DOC20/895186-3
8 December 2020

EPA Advice on Environmental Impact Statement

Thank you for the request for advice from Public Authority Consultation (PAE-10521210), requesting the review by the NSW Environment Protection Authority (EPA) of the Environmental Impact Statement (EIS) for the proposed Narrabri Underground Mine Stage 3 Extension Project (Application SSD-10269) at 10 Kurrajong Creek Road, BAAN BAA NSW 2390.

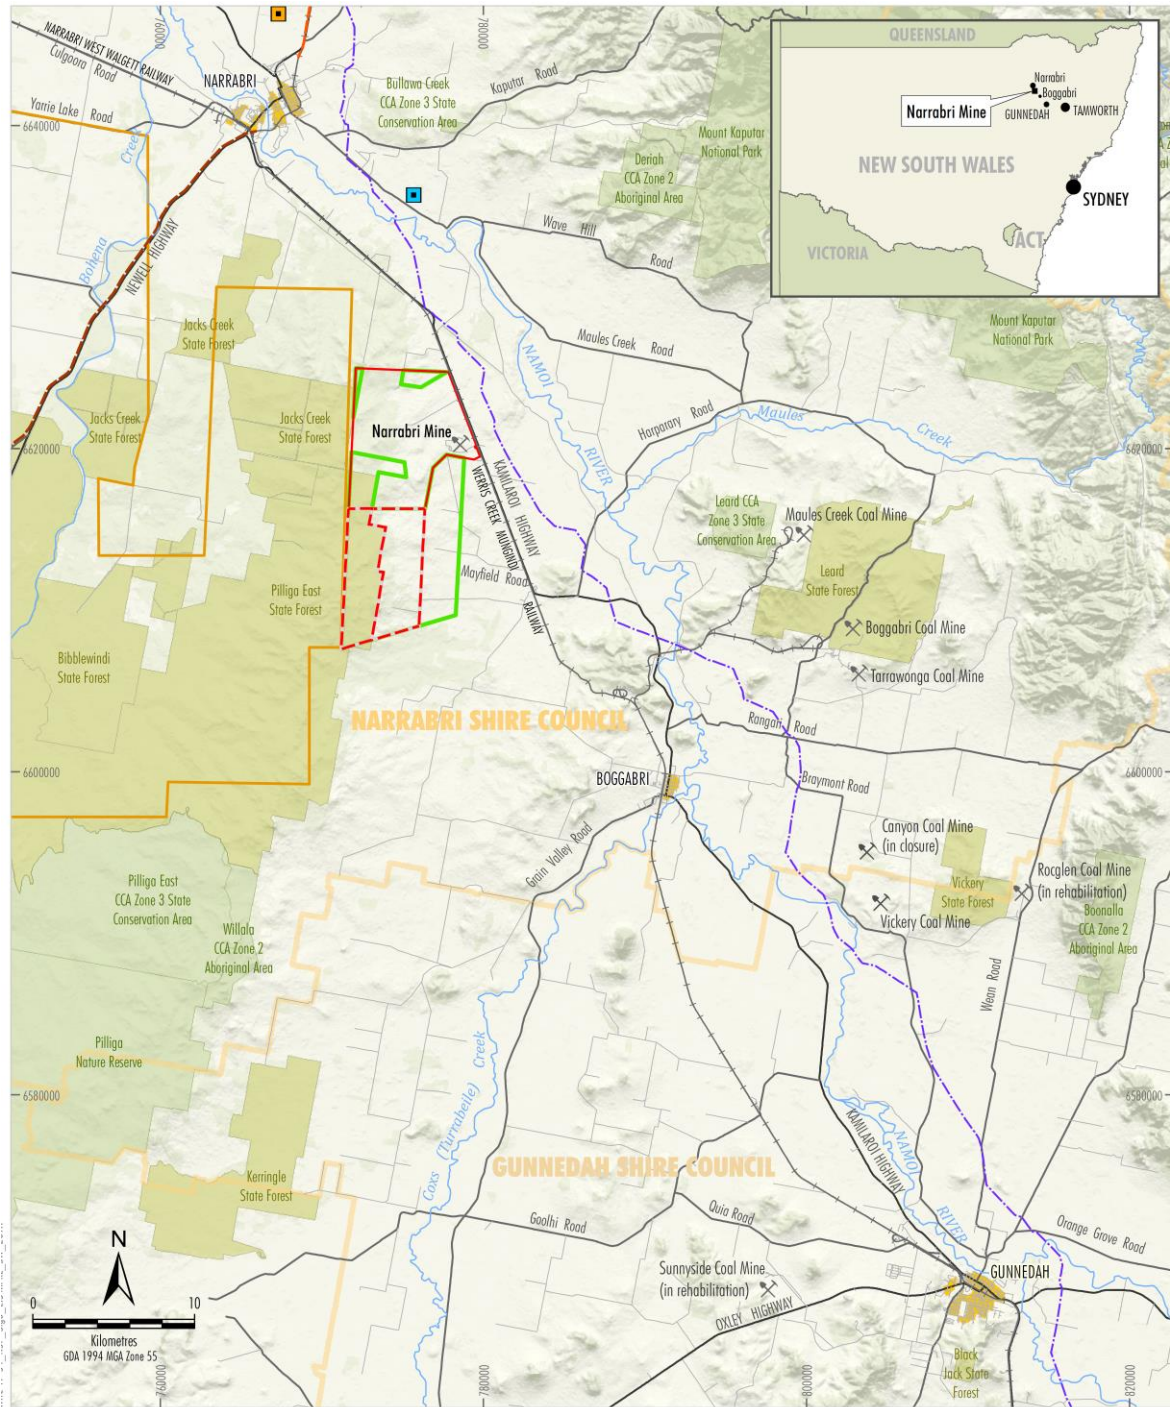
The EPA notes that an additional mine water storage is proposed to be constructed south of Longwall 210 (the Southern Mine Water Storage) (Figure 1.3 of Appendix C). This mine water storage is proposed be a “turkey nest” storage used to store mine water dewatered from the southern longwall panels, prior to transfer to the Pit Top Area.

The EPA recommends that the Southern Mine Storage is constructed to achieve a permeability of less than 1×10^{-14} m/s over a compacted clay depth of 900 mm or equivalent synthetic liner.
